From: Gregg, Robert <Robert.Gregg@lancashire.gov.uk>
Sent: 12 September 2018 15:52
To: Adam Birkett
Cc: planning; LHS Customer Service
Subject: APP. 3/2018/0643 - 10 KNOWSLEY ROAD, WILPSHIRE.

After receiving the revised plans,
While taking into consideration that the proposed parking areas boundary wall would be moved further back out of the adopted service verge along with further alterations being made towards the betterment of the prior proposed parking arrangements.

PROPOSED SITE PLAN

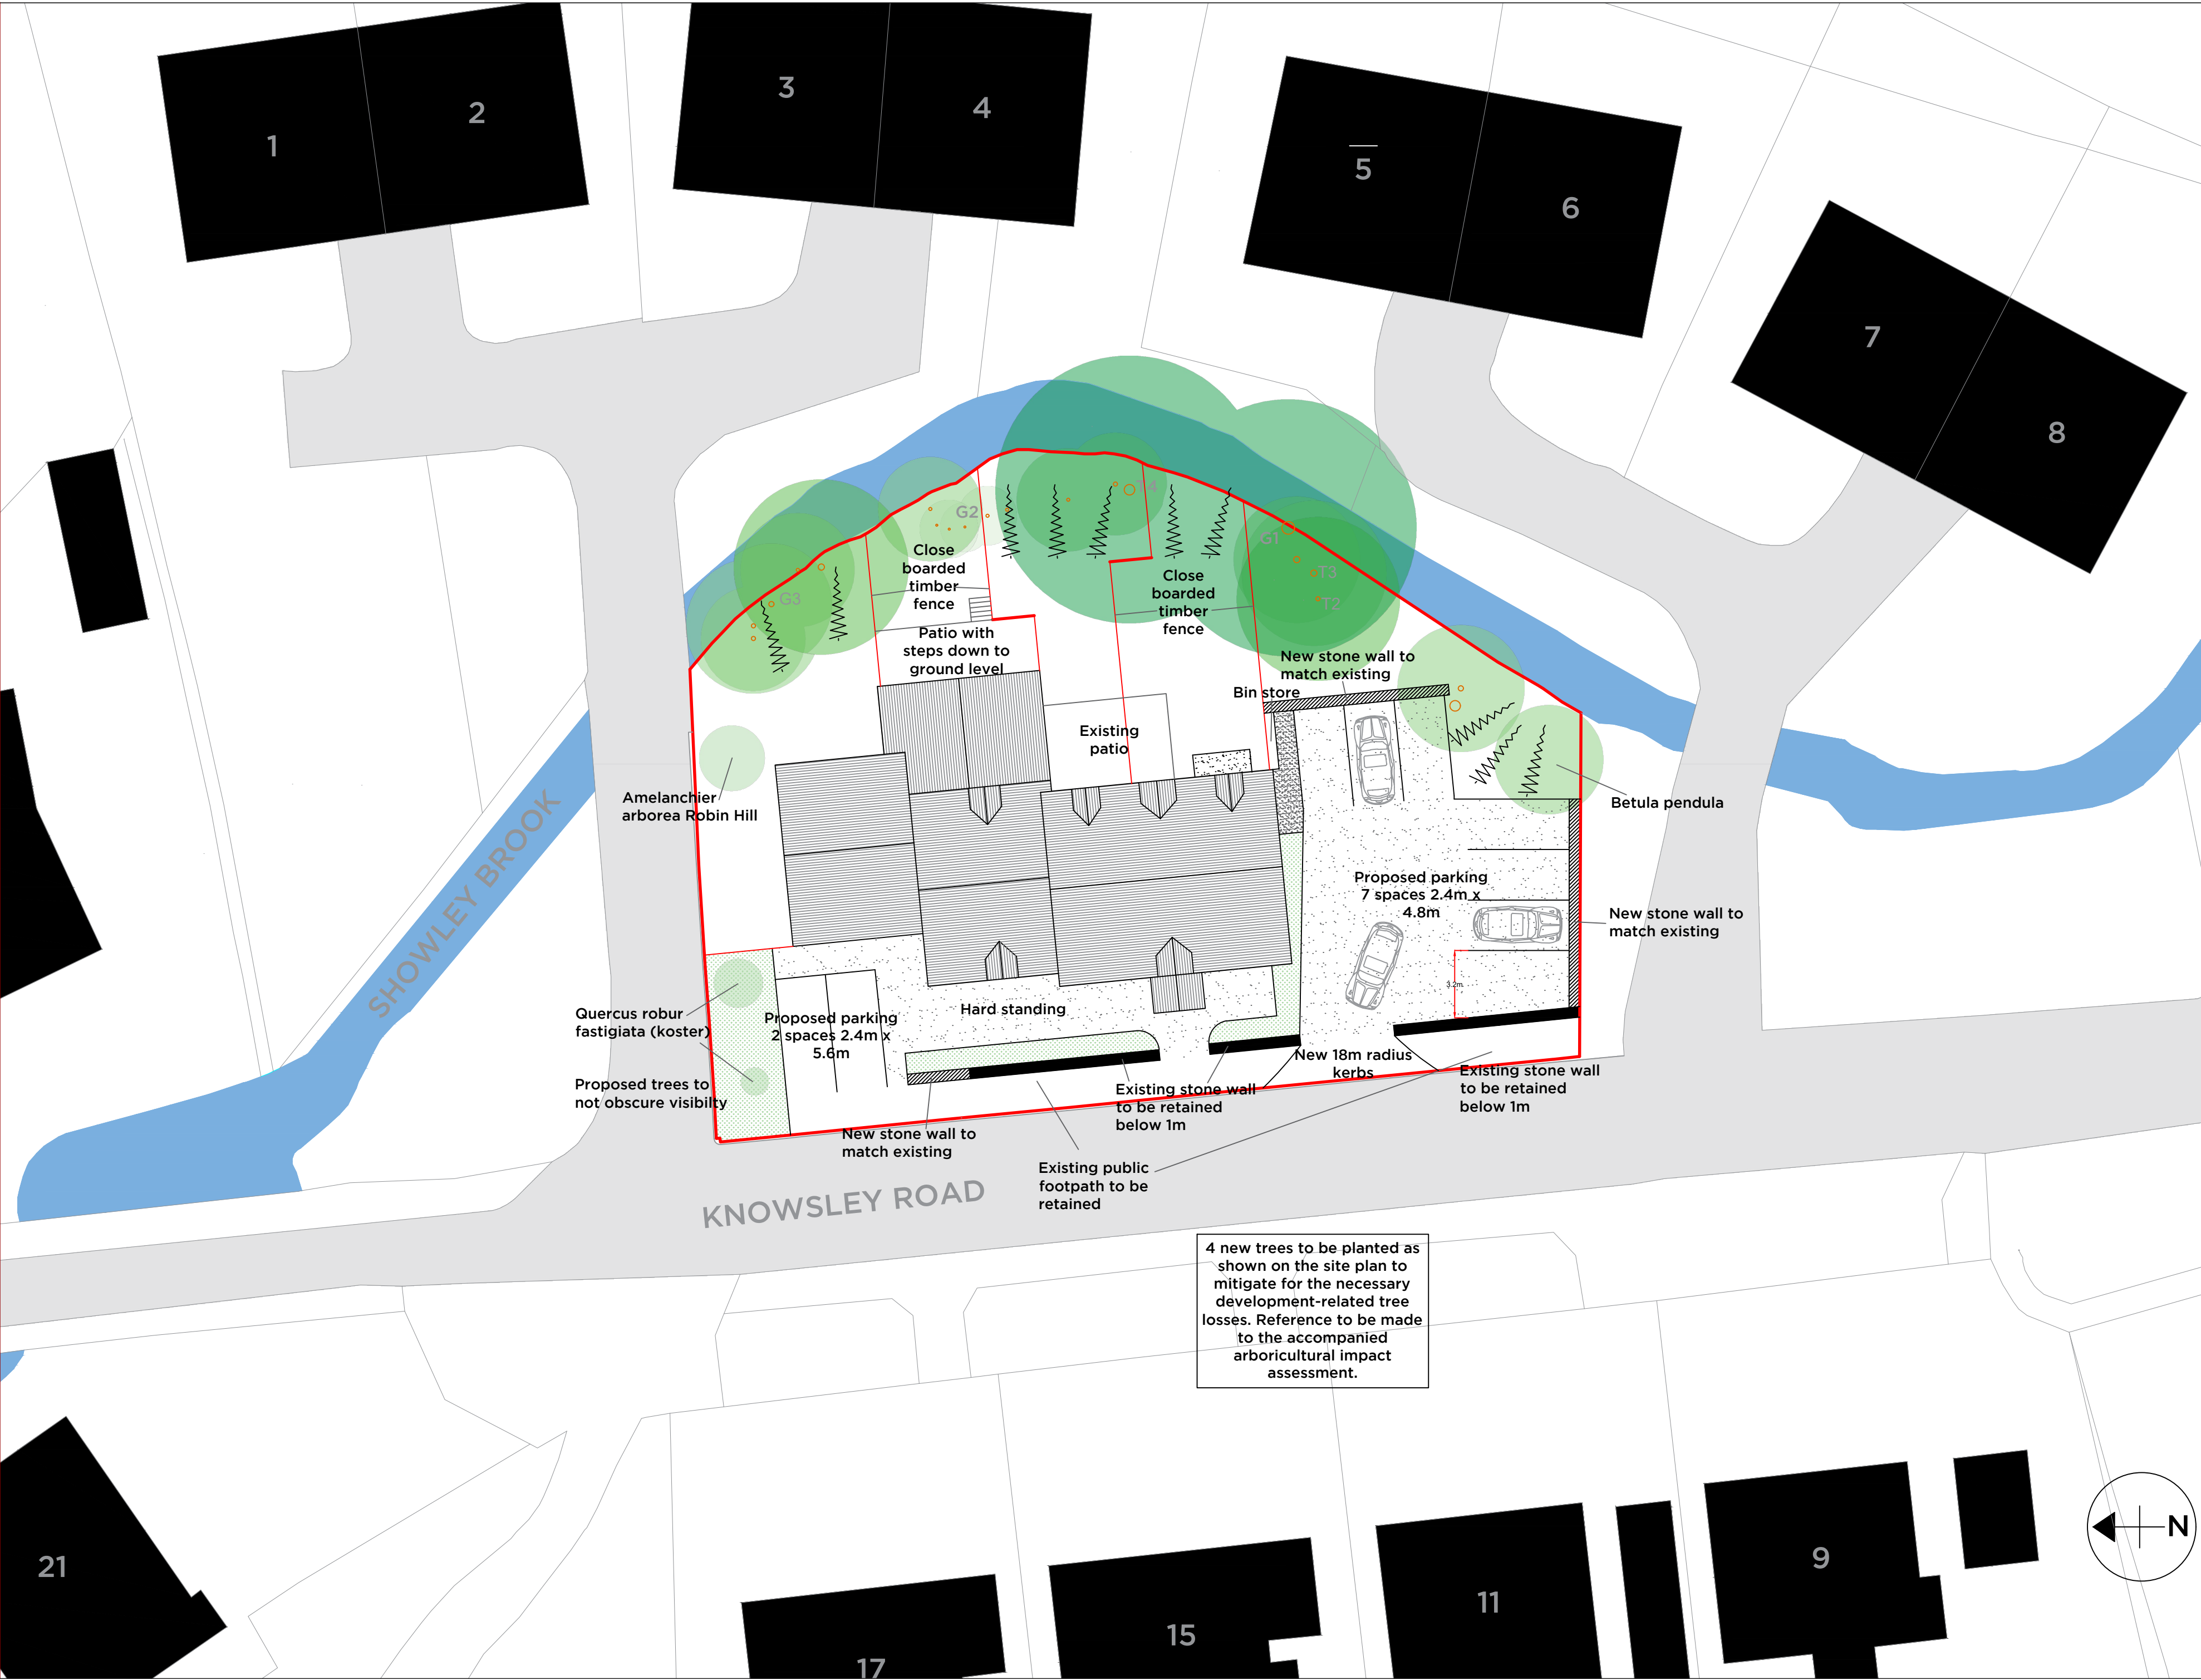
I would raise no objection towards this proposal on highway grounds.

1. The layout of the development shall include provisions to enable vehicles to enter and leave the highway in forward gear and such provisions shall be laid out in accordance with the approved plan and the vehicular turning space shall be laid out and be available for use before the development is brought into use and maintained thereafter. Reason: Vehicles reversing to and from the highway are a hazard to other road users.
